Transport Assessment

Proposed Customer Fulfilment Centre

Horsley Drive Business Park Stage 2, Horsley Park

Ref: 1223r03
19/06/2020

1 CARPARK - GROUND FLOOR-DA
 A135 Scale: 1:400

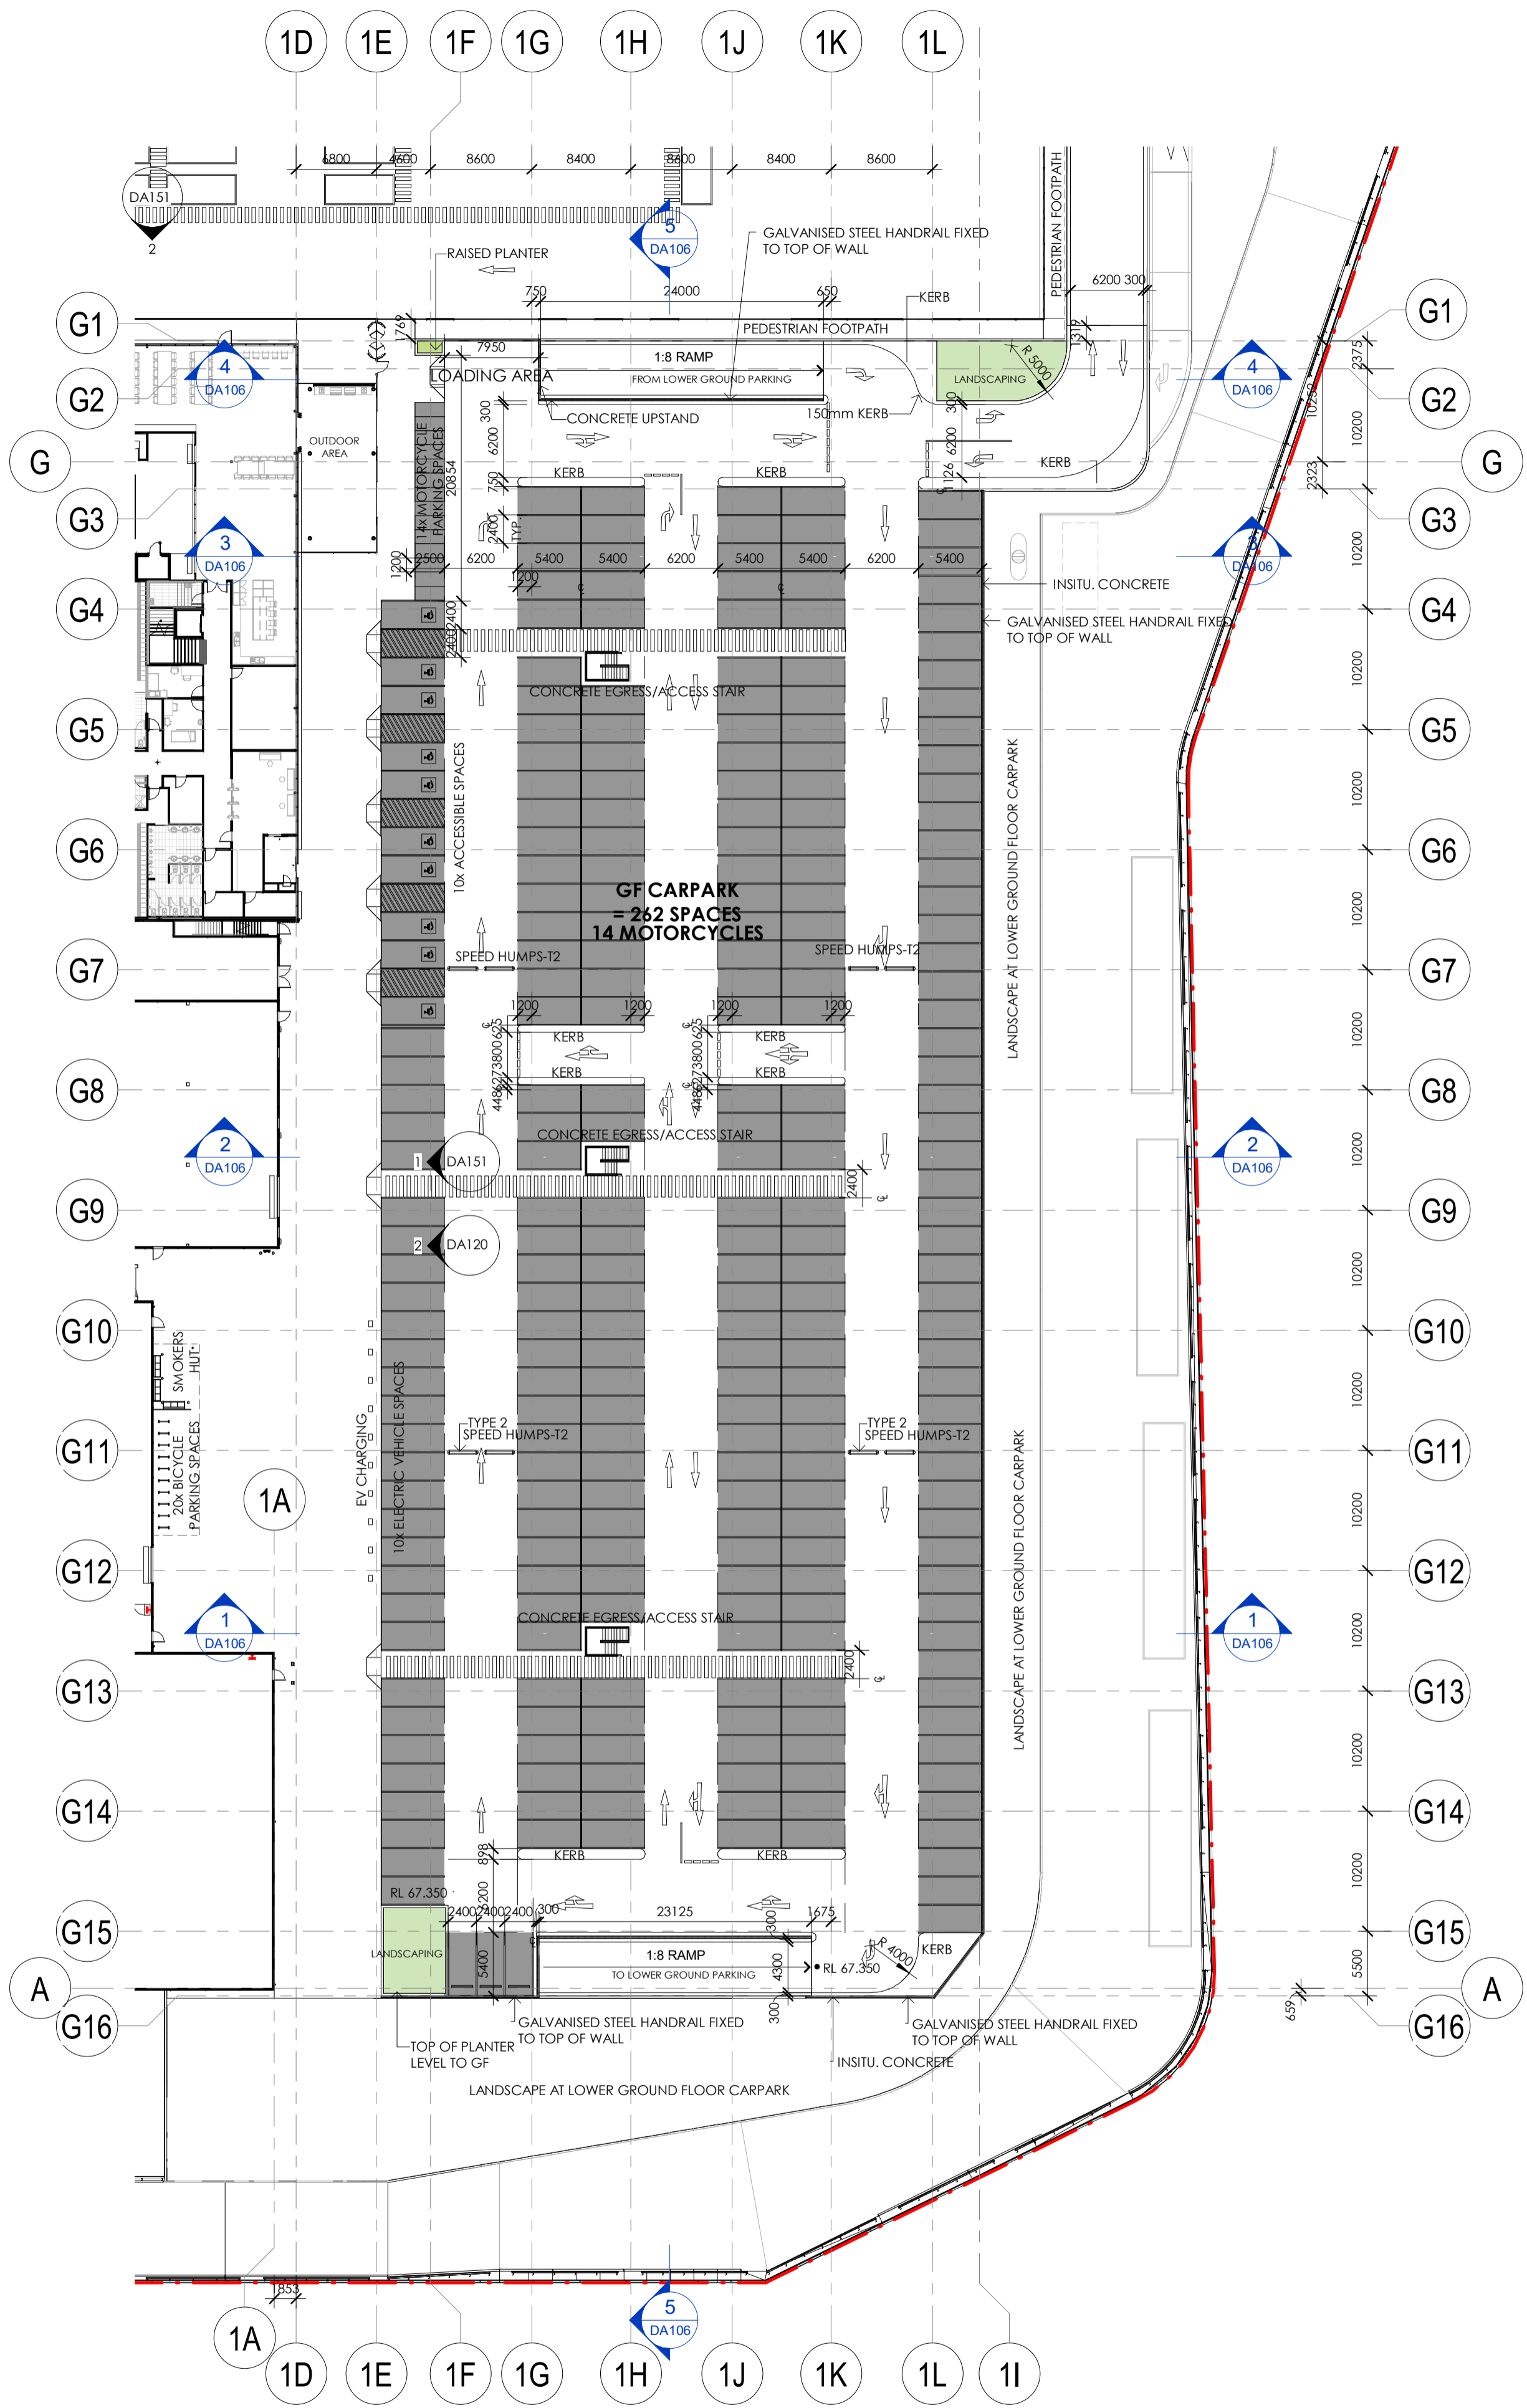
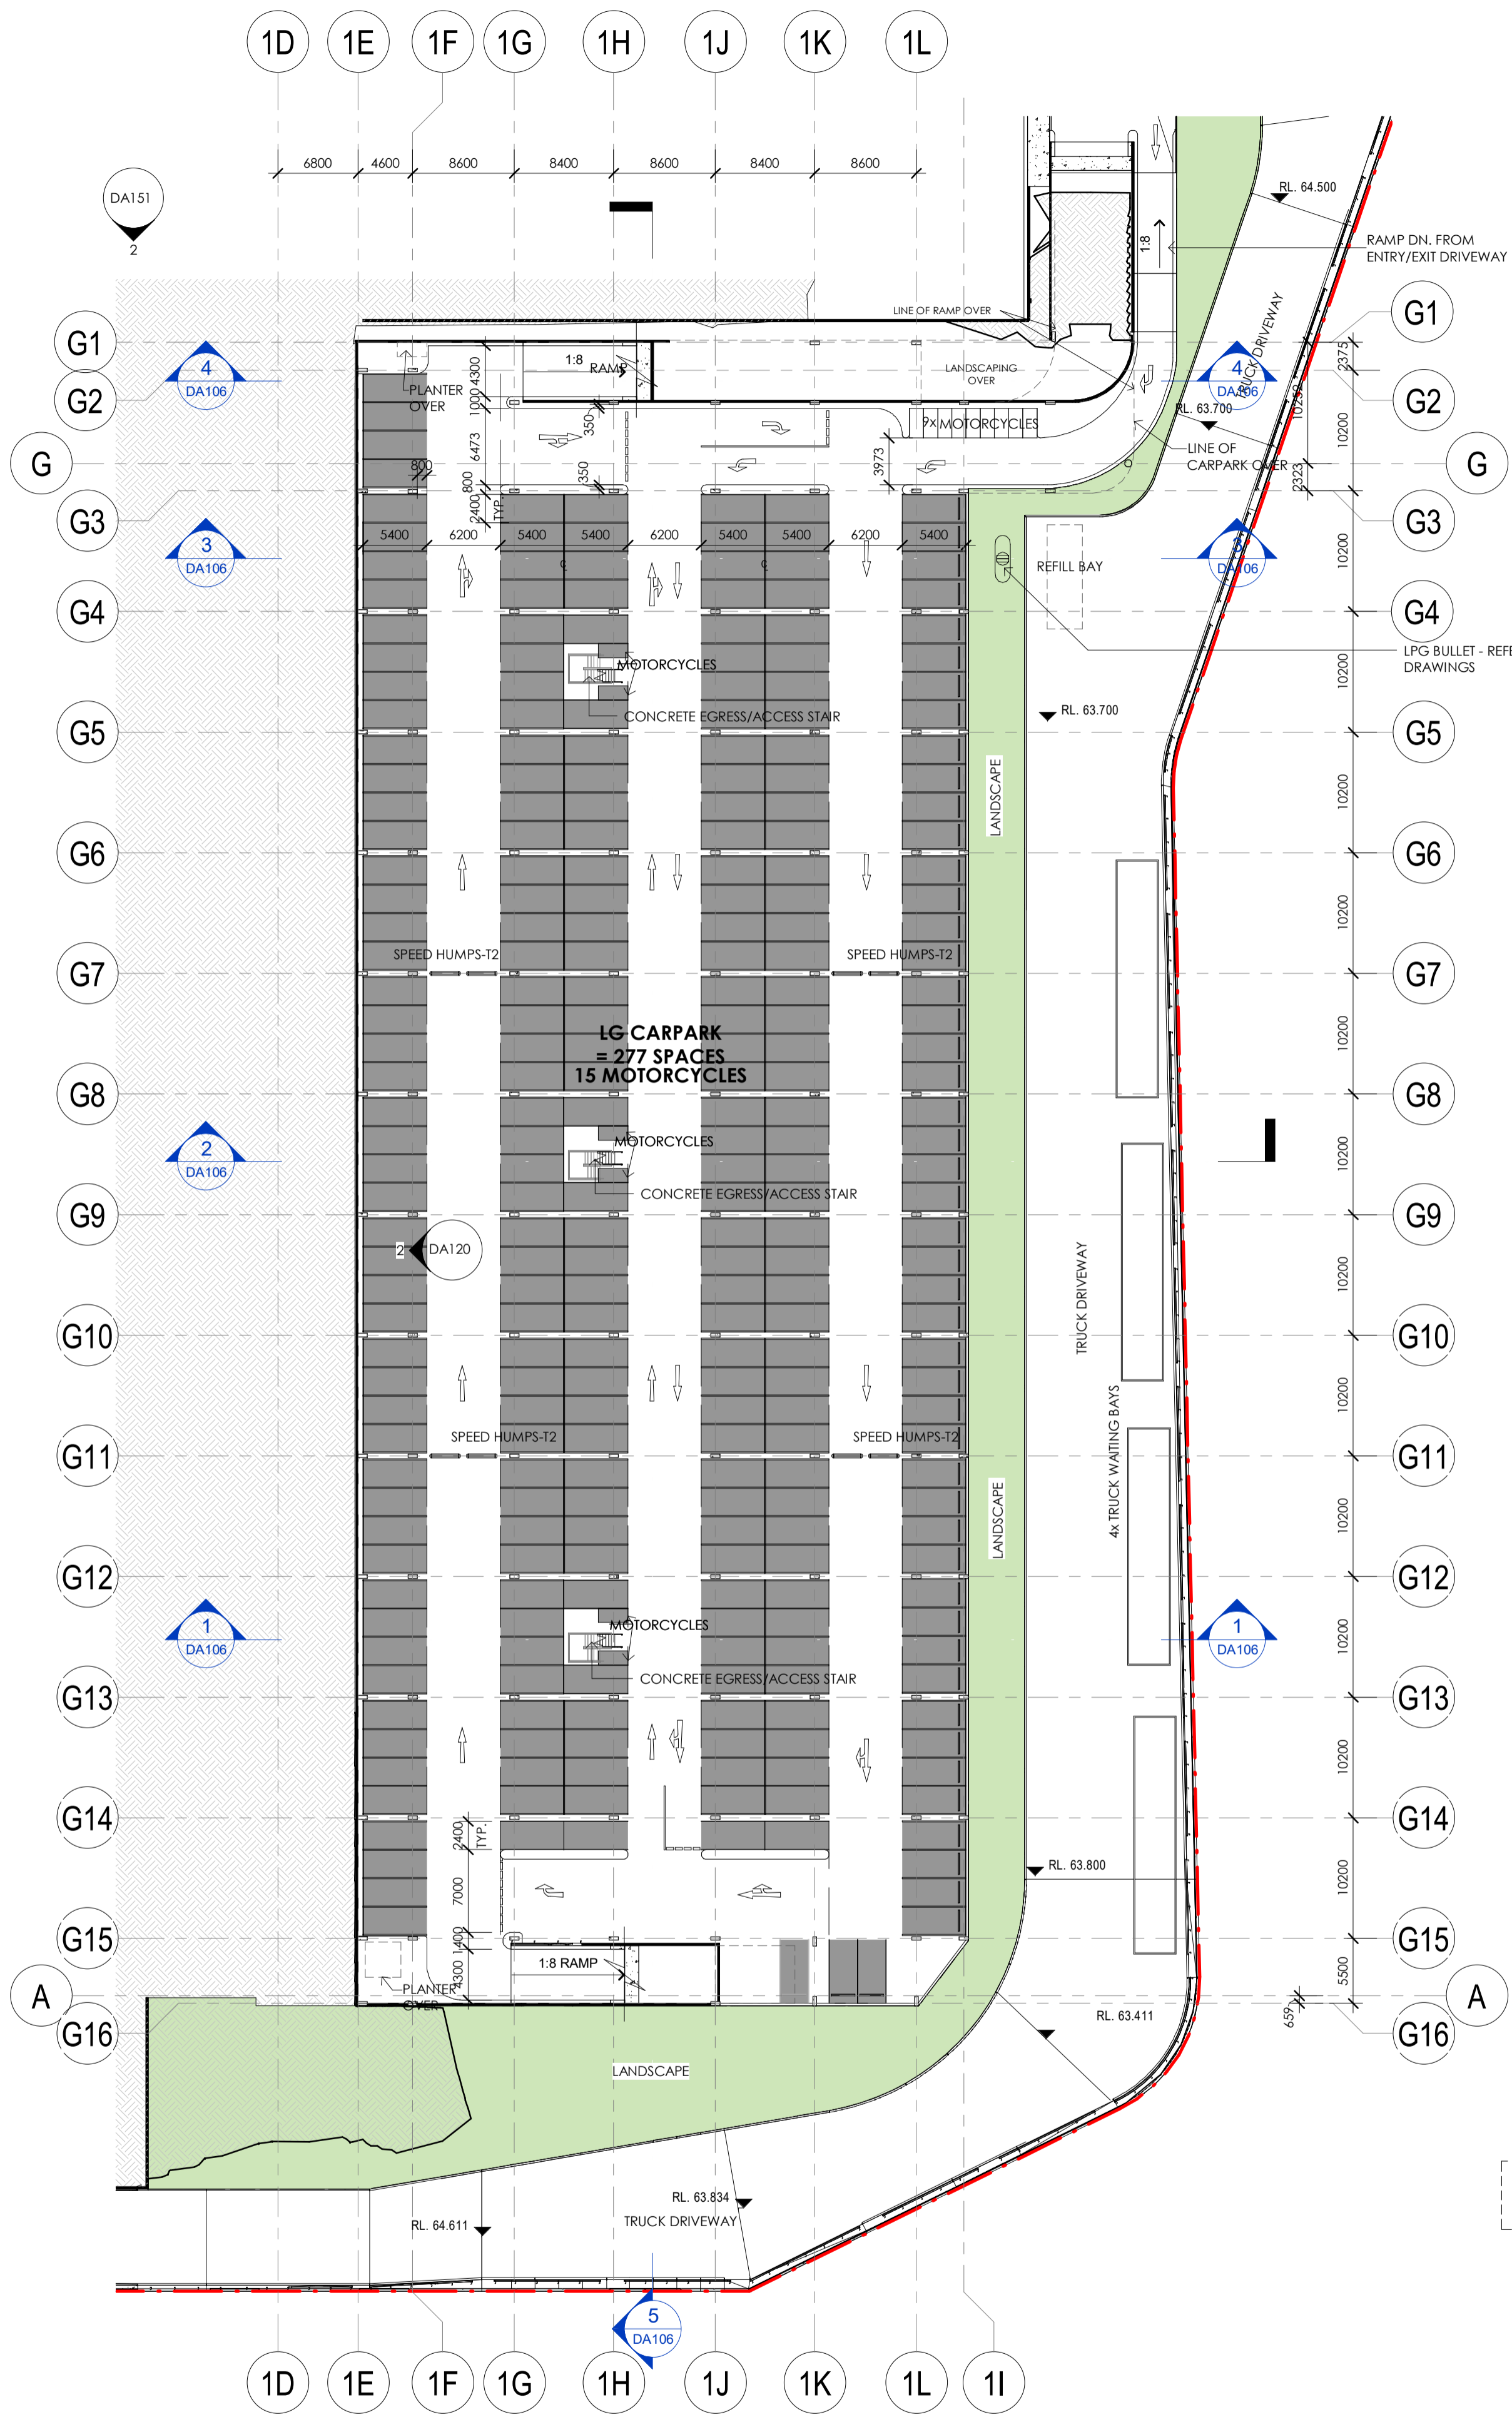
12	<p>Longitudinal sections of the proposed access driveways for service vehicles/deliver vehicles to access the site shall be submitted to Council for assessment.</p>	<p>Please refer to Civil Engineer response / Updated architectural plans.</p>
13	<p>A review of the site plan indicates that parking spaces are proposed in a stacked arrangement at the south-western corner of the site. According to the Fairfield City Wide DCP, Council generally does not favour the use of stacked parking within the site unless further justification is provided. In this regard, the applicant is required to submit Council further information in regard to the management of stacked parking. The applicant shall demonstrate that the provision of stacked parking arrangement will not adversely affect the safe, efficient and effective use of the site.</p>	<p>The south-western corner of the Site has now been revised to provide for trucks. Trailer parking bays are proposed along the western side of the Site. Stacked parking is only proposed at the van pen parking area.</p> <p>These spaces would be operated by staff who are skilled heavy vehicle drivers who would park the vehicles there for storage or for waiting purposes, in line with the operational management plan. They would not be for general staff parking.</p>
